Subject: Comments regarding planning application AW/259/18/PL.

Re: Planning Application AW/259/18/PL - 10 Barrack Lane, Aldwick, Bognor Regis PO21 4BZ.

Block Plan 1 : 500

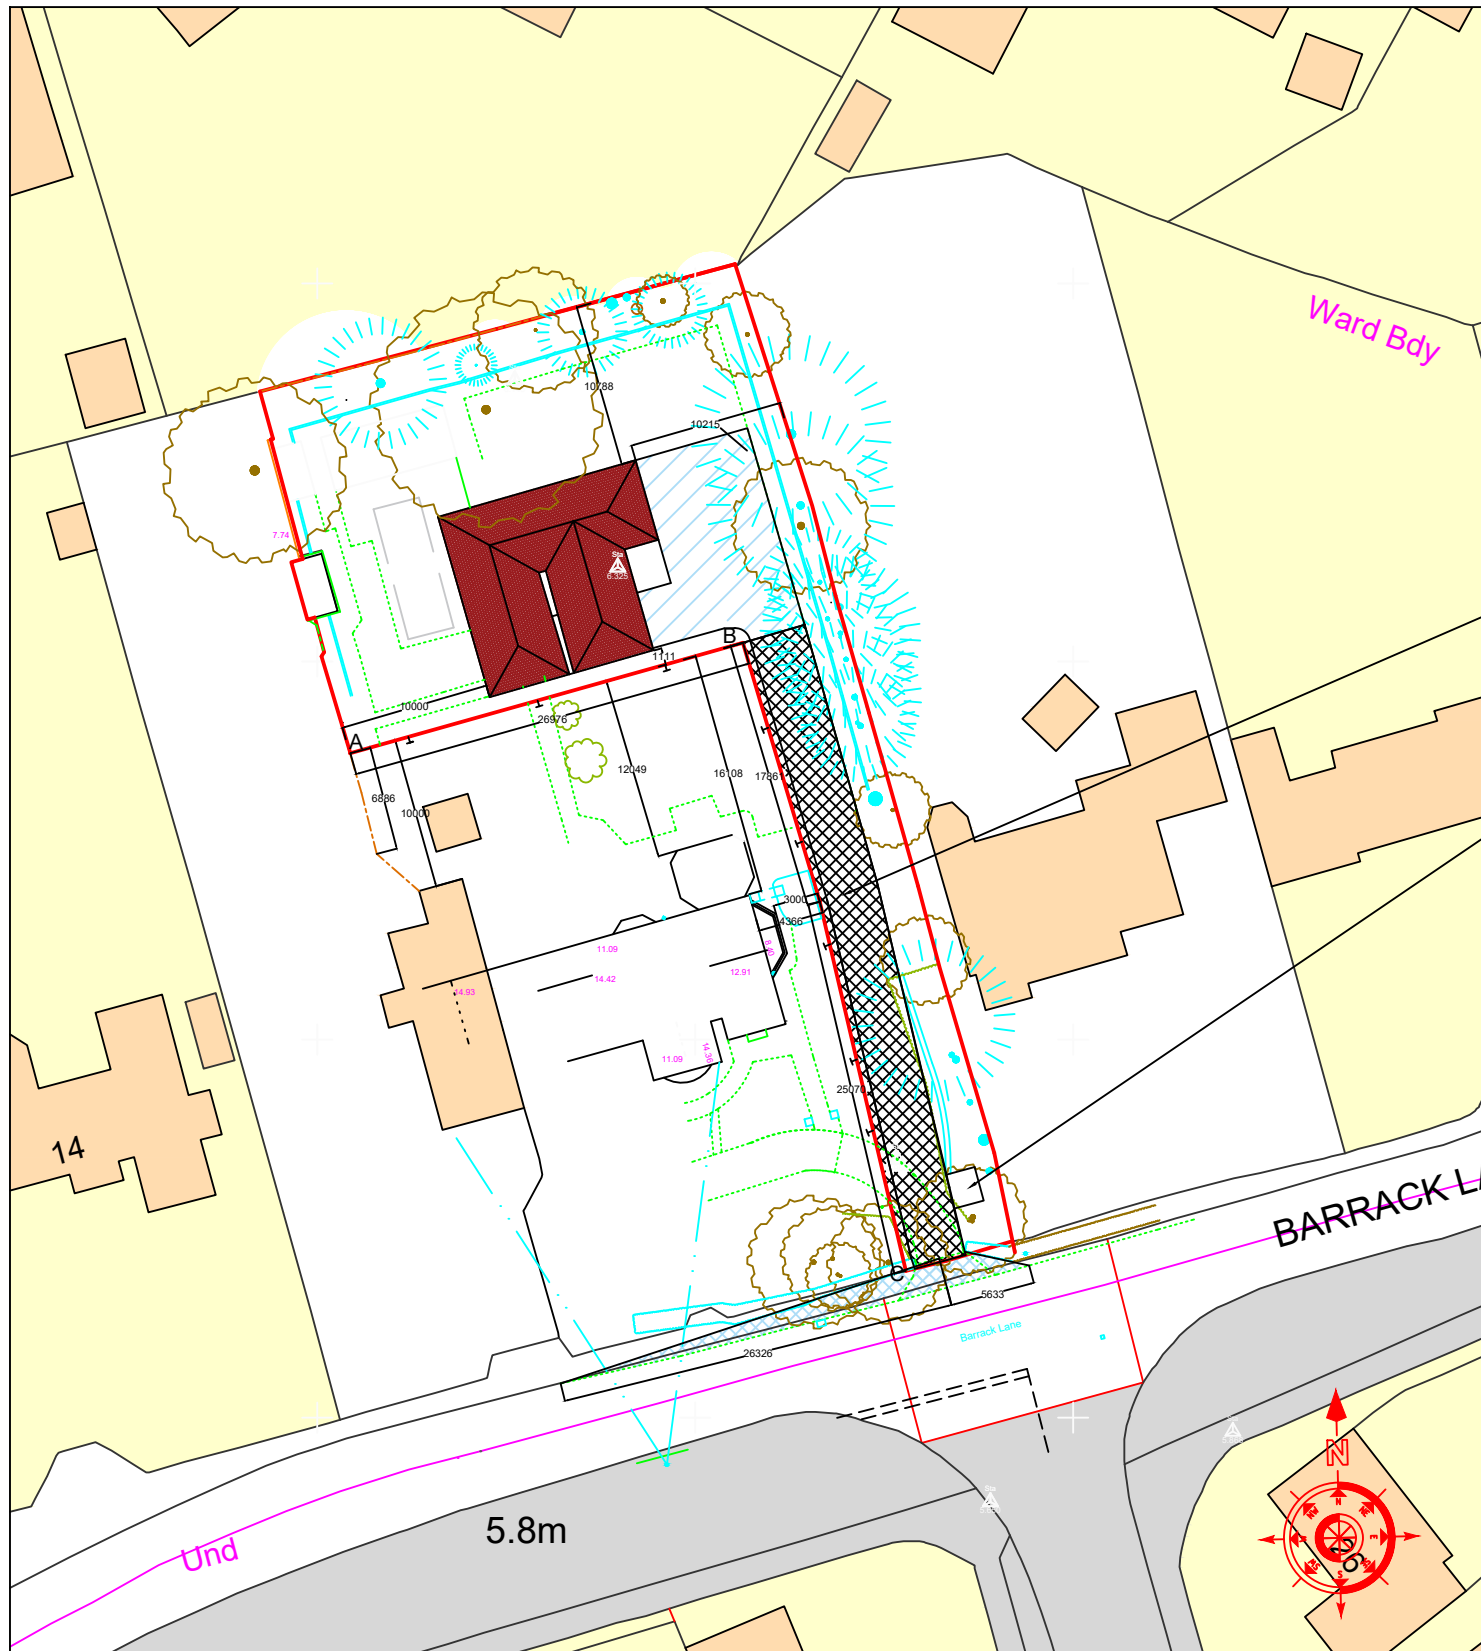
Looking at the site plan the roof ridges at the same height do not correspond with the elevations indicating ridges at a different height.
